ADDENDUM

Project: Science Building Research Wing Expansion

Project No. 03049

Addendum: No. 1

1 PENTHOUSE PLAN - NEW POWER
1/8" = 1'-0"

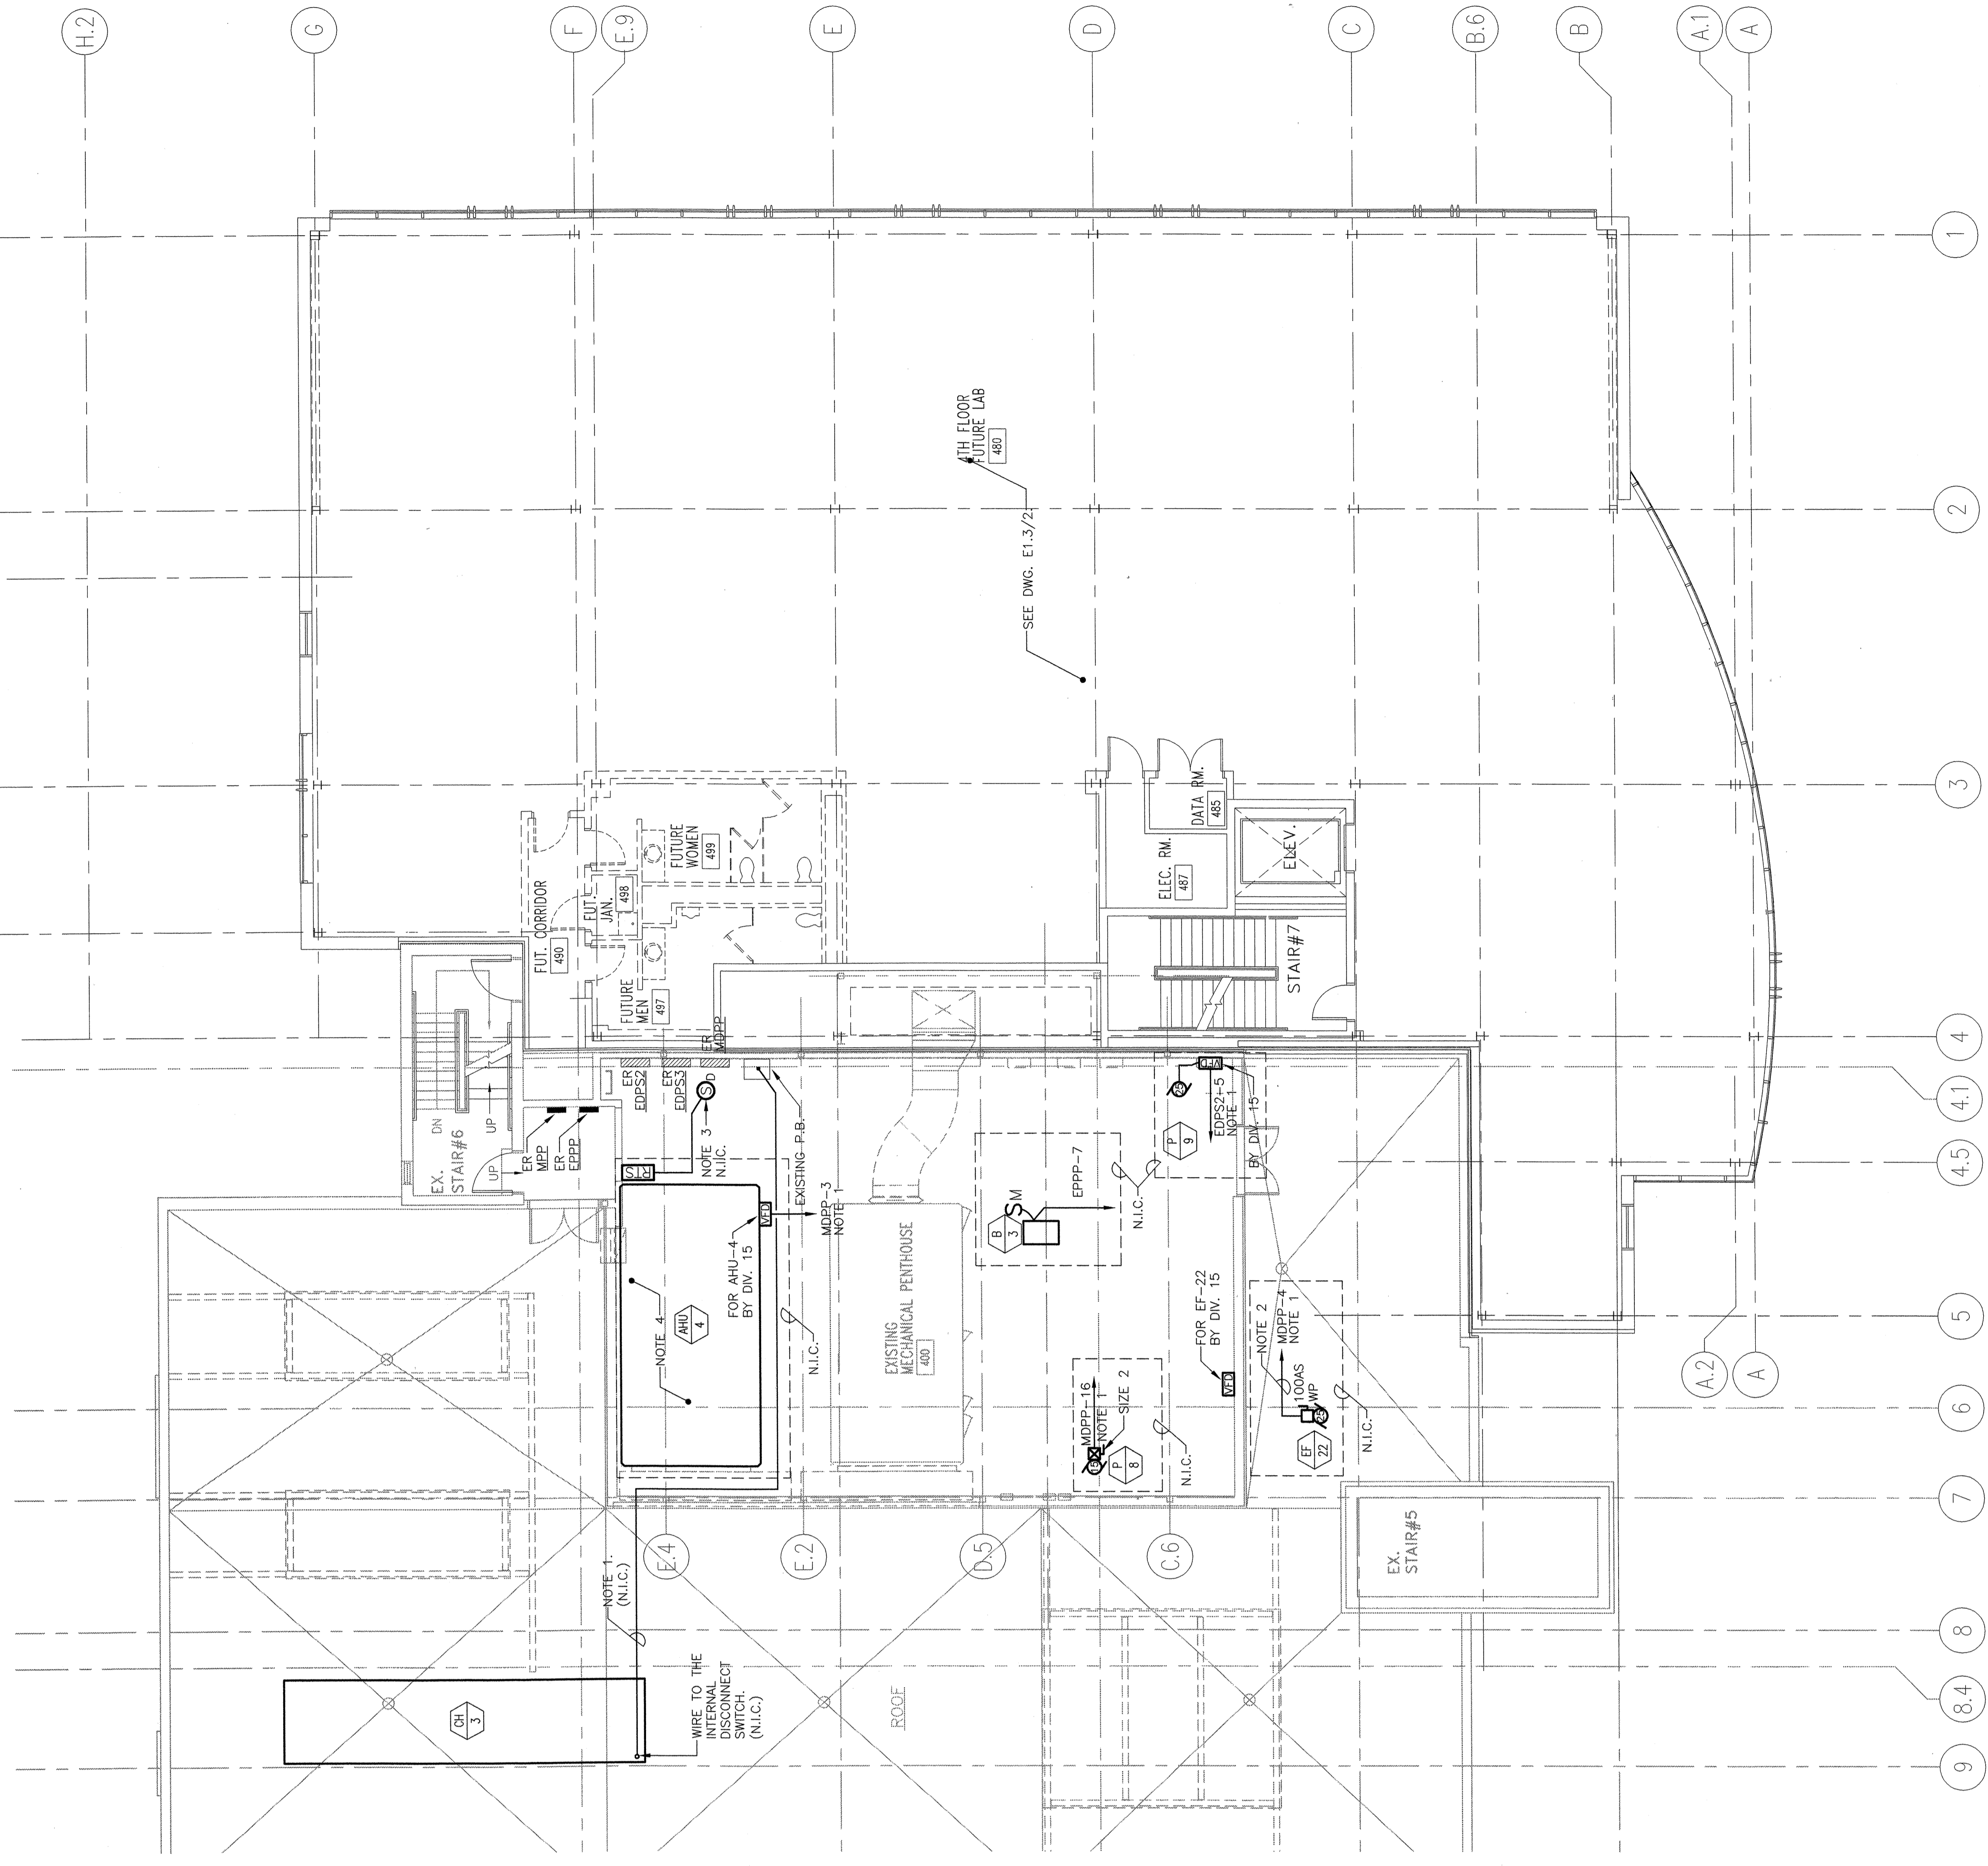
1. Make changes shown on SKE-05.

SECOND FLOOR & PENTHOUSE PLANS

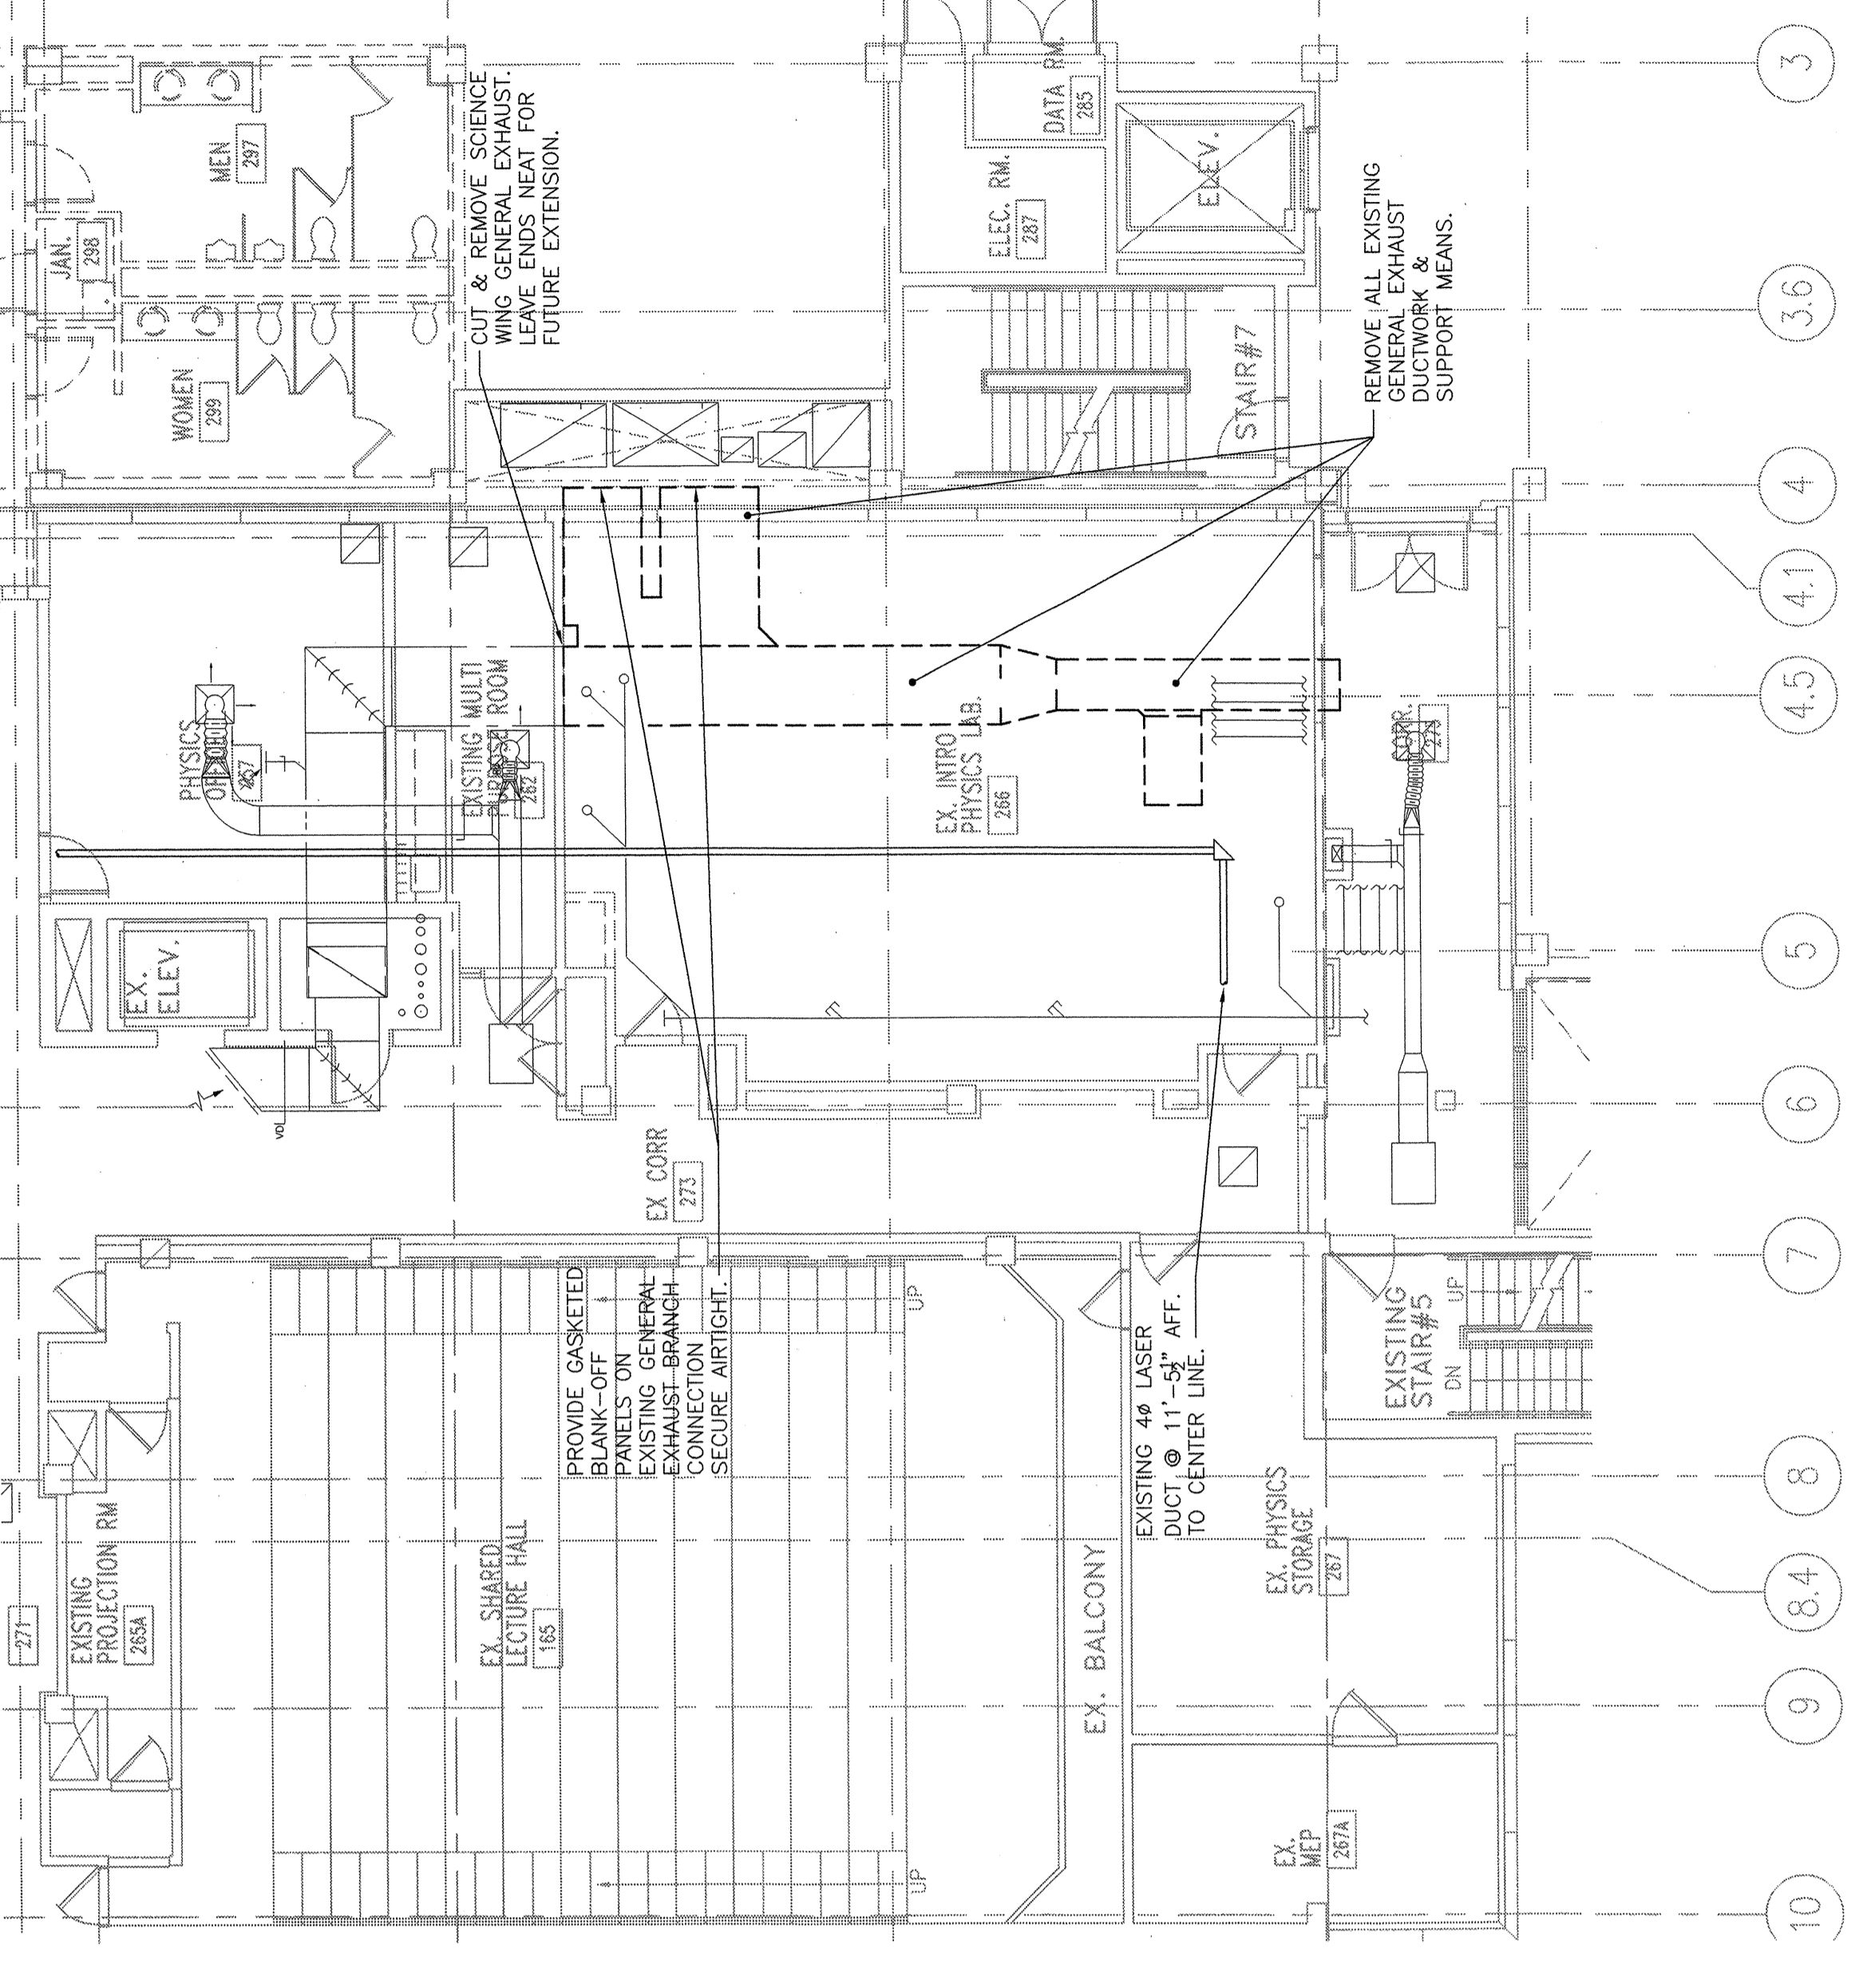
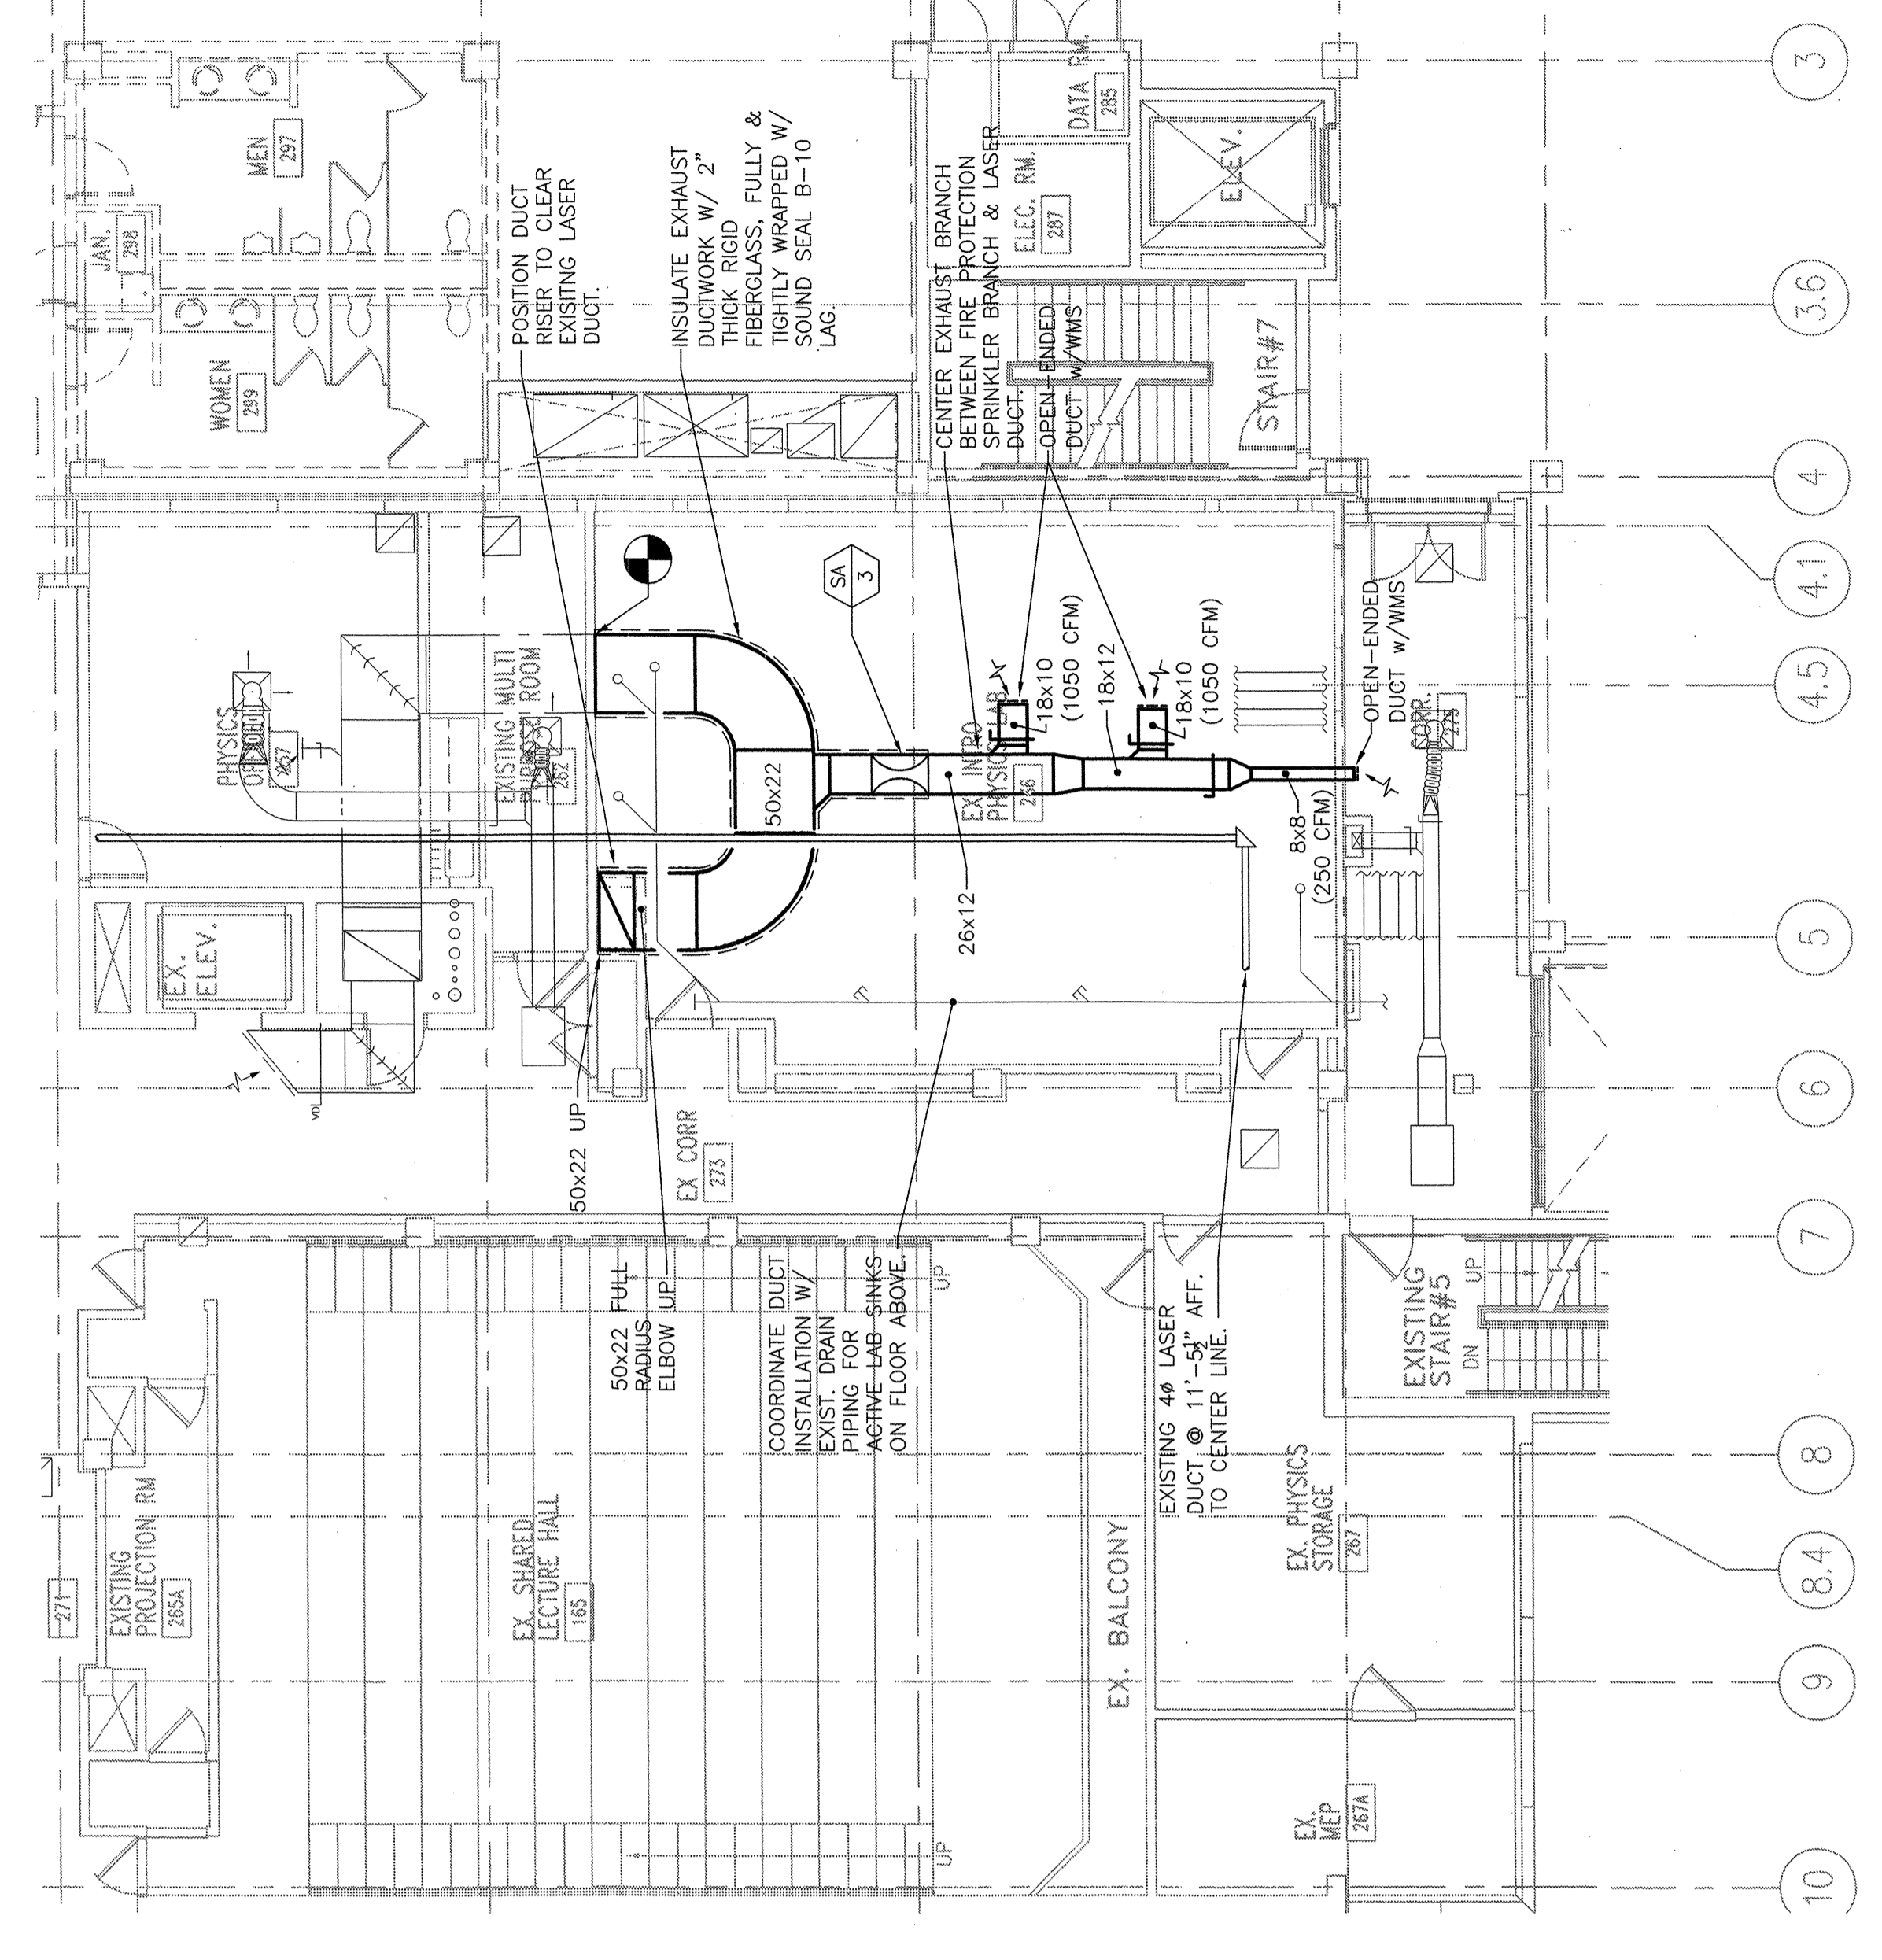
1. Change note at EF/22 to read "Extend 4" ERS7R across roof I connect to coil in EF-22-ERU. Provide shut-off and balance valves."
